Welland & Deepings
Internal Drainage Board
Deeping House
Welland Terrace
Spalding
PE11 2TD

27th February 2012

Re: Taylor Wimpey East Midlands Ltd, Wygate Park South, Spalding, Lincs
Details of Surface Water Disposal

WBP Drawing Number:
E2239/14/A

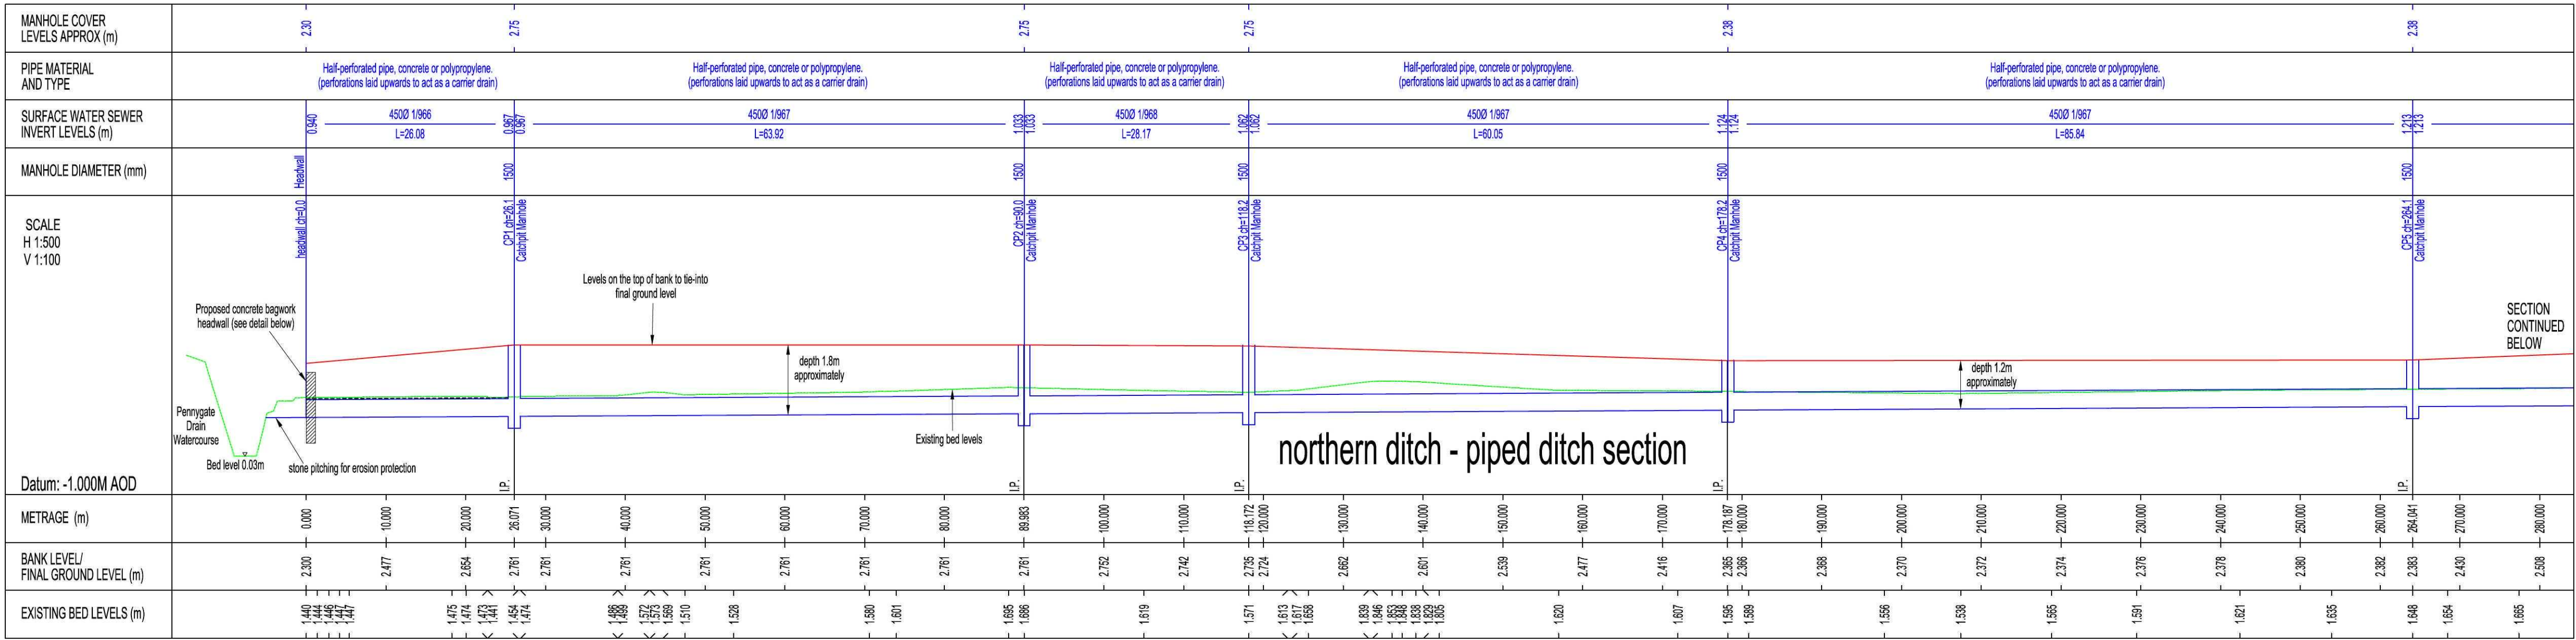
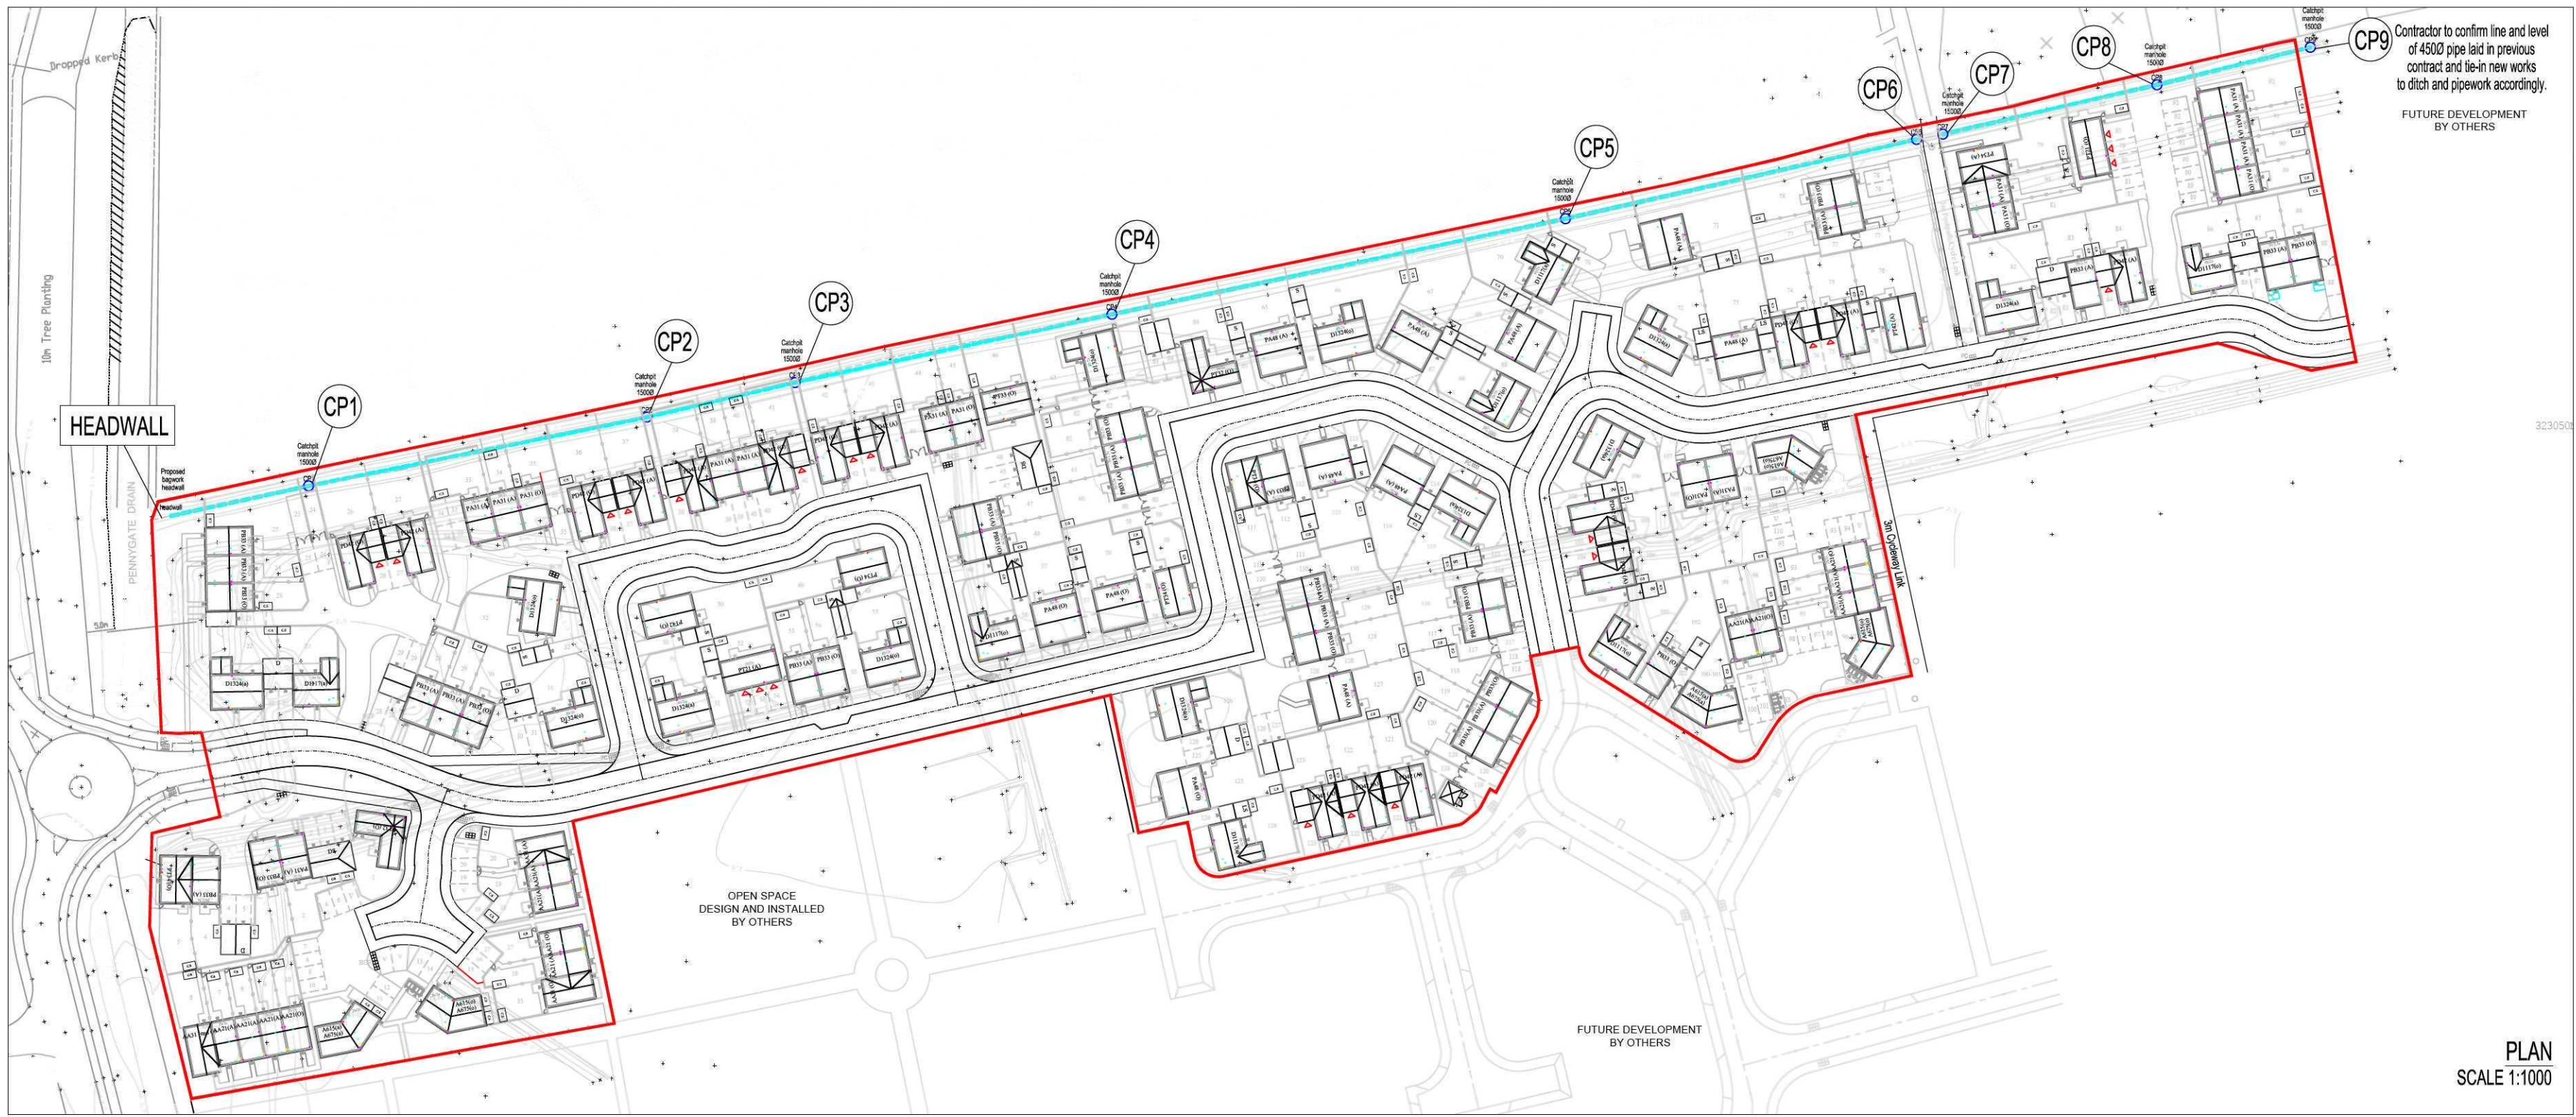
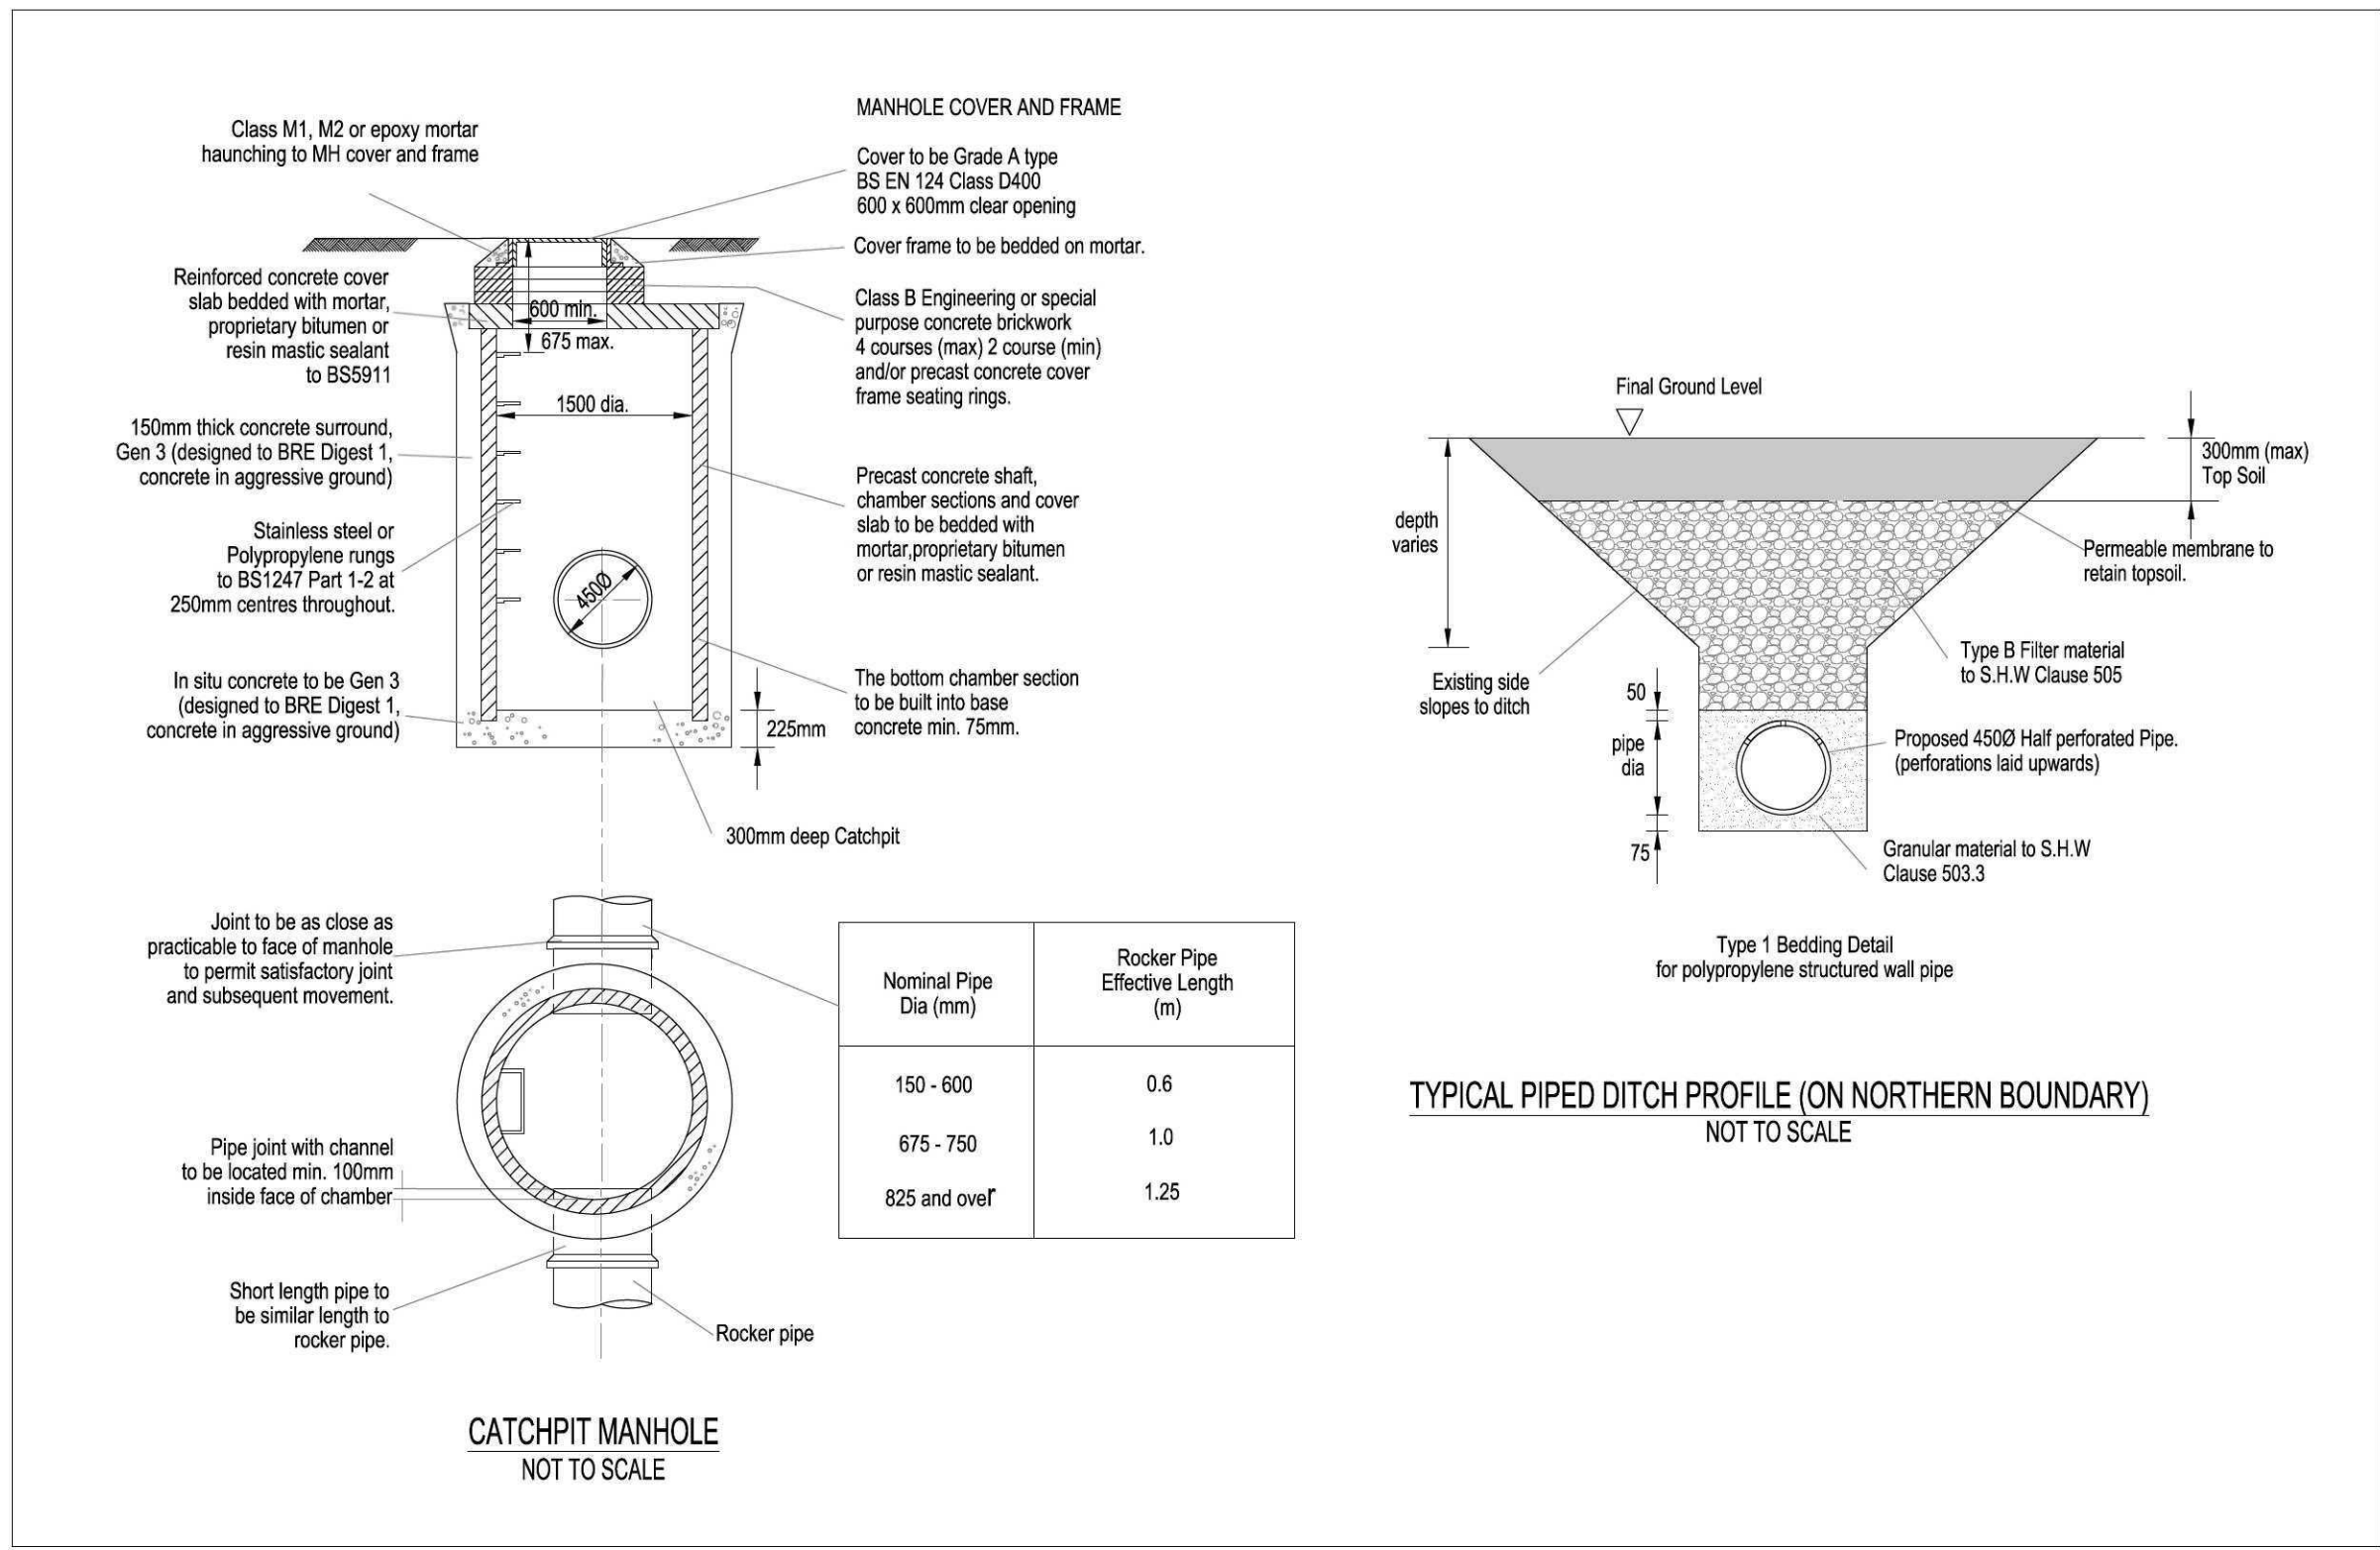
The proposed details for the culverting of the northern ditch, as shown on drawing numbered TWY014/113/A, is acceptable to the Board.
